**Approval of details reserved by condition imposed under ref APP/C3810/W/16/3155330 (AL/8/16/OUT) relating to Condition Nos 11 - visibility splay, 12 - fire hydrant, 13 - foul drainage, 14 - surface water drainage and 18 - external lighting**

**Land To South Of Barnside Hook Lane Aldingbourne PO20 3TE**

Arun District Council have decided to **REFUSE details reserved by condition for the following reasons:**

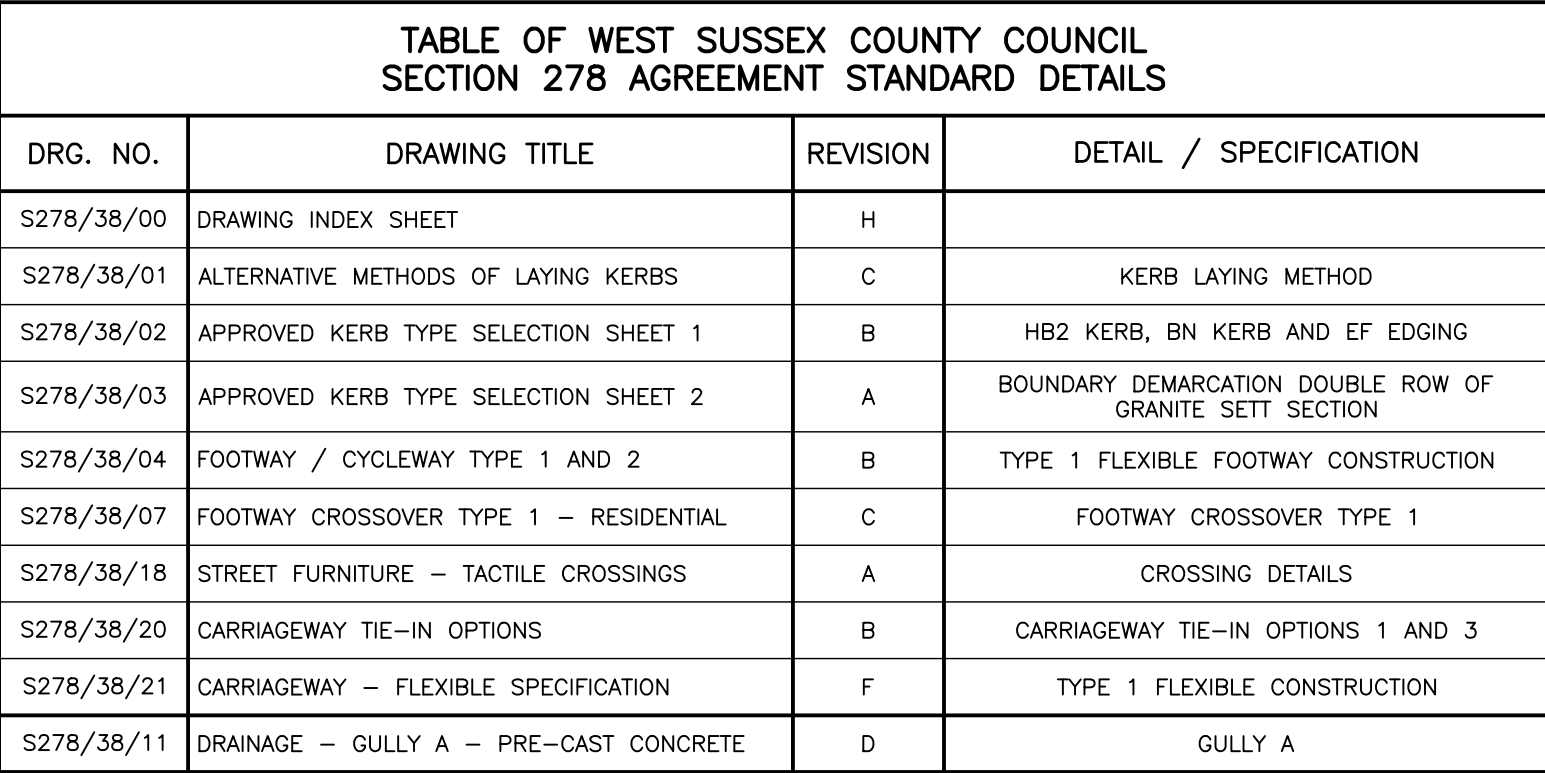
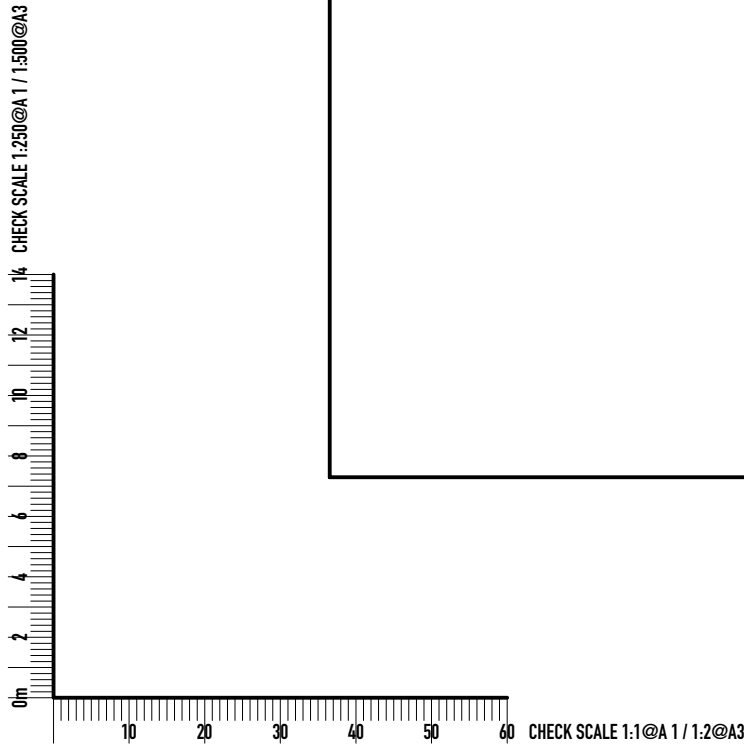
The condition requires details of a fire hydrant, its connection to a water supply (which is appropriate in terms of both pressure & volume) and details of maintenance. Your plan "Proposed Site Plan" Feb 19 shows the location of a Fire Hydrant with a connection via a new 90mm pipe. The submission does not clarify that the water pressure is sufficient for the purposes of fire fighting and does not include any details as to future maintenance. Therefore, the Council is unable to discharge this condition at the present time and you will need to make a revised submission.
